Arun District Council
Arun Civic Centre
Maltravers Road
Littlehampton
West Sussex BN17 5LF
Planning & Building Control General Enquiries
Tel: (01903) 737756 Fax: (01903) 730442
Dx: 57406 Littlehampton
Minicom: 01903 732765
e-mail: planning@arun.gov.uk
website: www.arun.gov.uk/planning

Application No: AW/294/21/HH
Site Address: 59 Marlborough Court Aldwick PO21 5QJ
Description of works: Erection of single storey side extension, involving demolition of attached garage, single storey side extension to other side to create garage and utility room and loft conversion with 1 x rear dormer

Thank you for your internet representation made on 28th September 2021 which has been recorded as an objection with the comments as follows:

PROPOSED ELEVATIONS

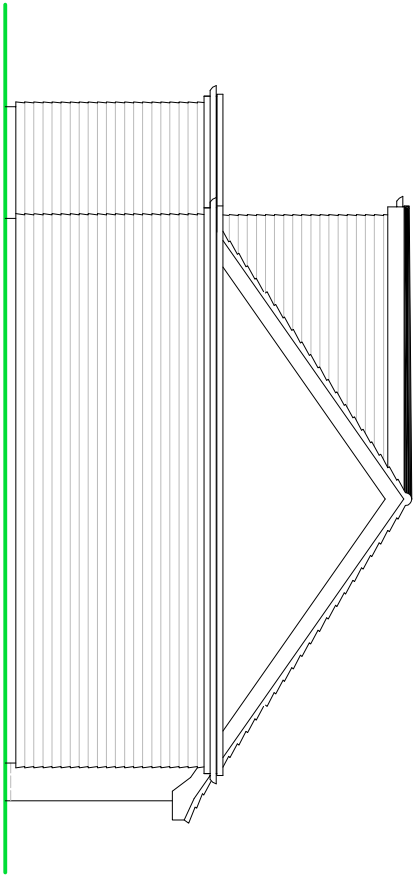
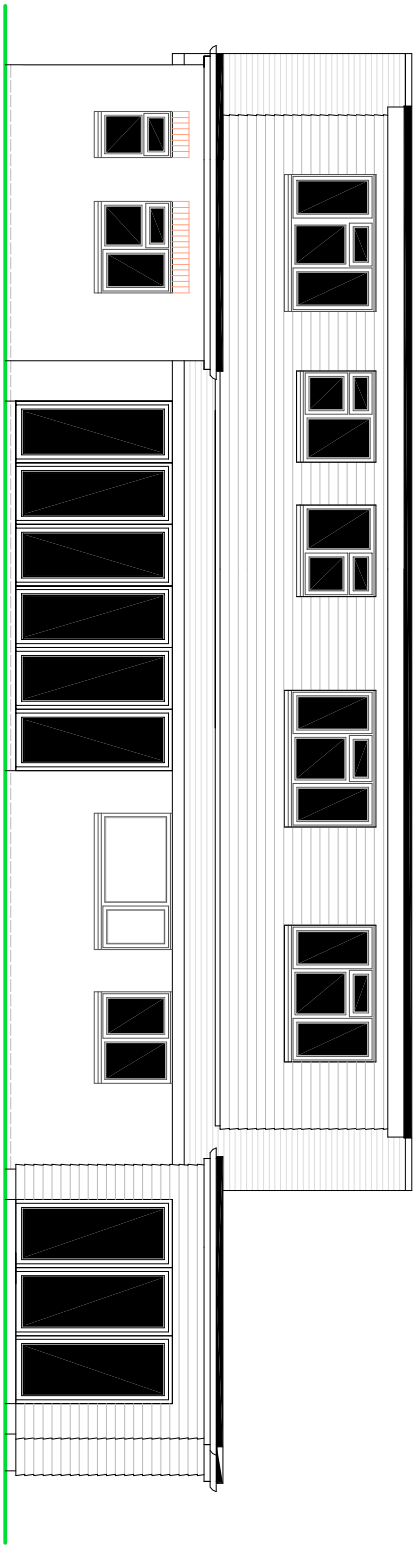
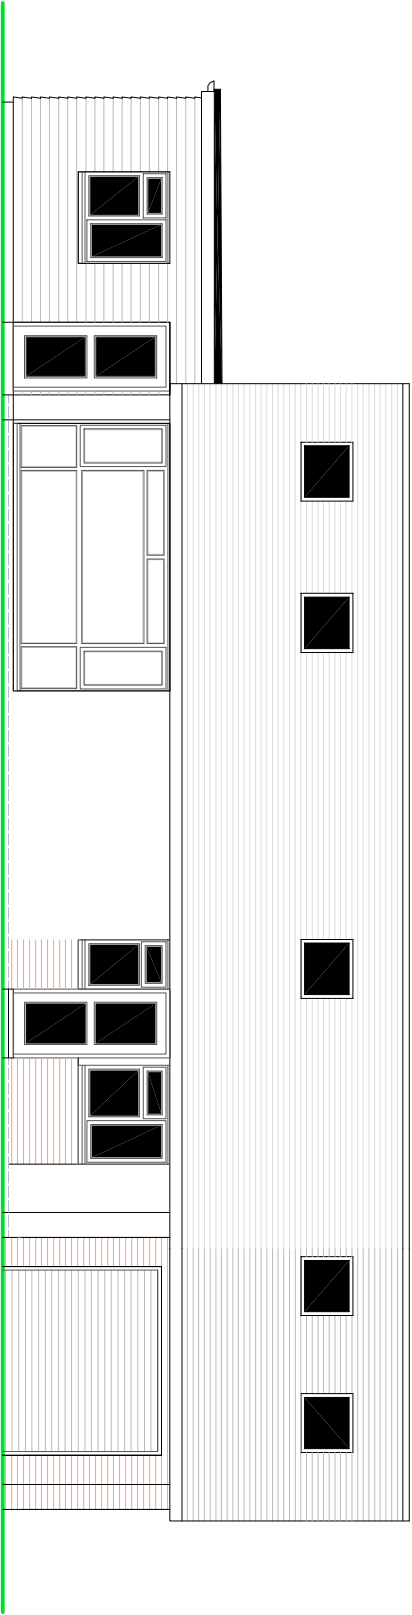
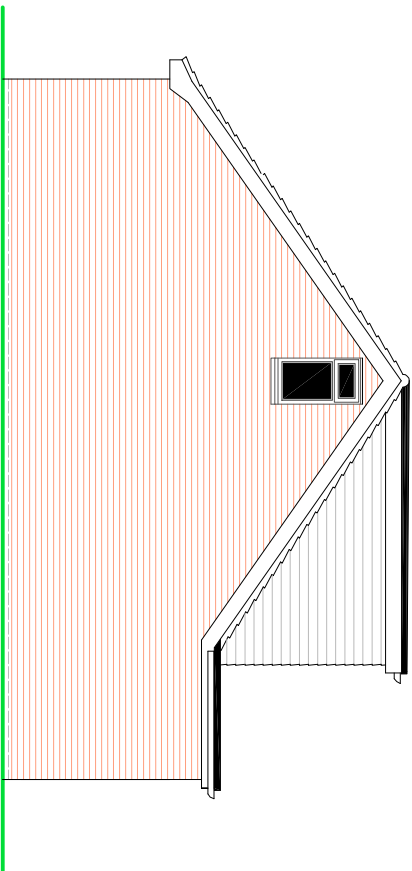
Members strongly objected to the application on the grounds that the proposed
Extension does not sympathetically relate to the existing building in siting,

Or scale; because the proposed extension is not visually subservient to the
main

Building; because the proposed extension has an adverse overshadowing,
overlooking or overbearing effect on neighbouring properties; and because
the extension compromises the established spatial character and pattern of
the

area. Therefore Members agreed that the proposed extension is in direct
conflict with policy D DM4 of the Arun District Local Plan 2011-2031 and with
the Parish Design Statement page 70.
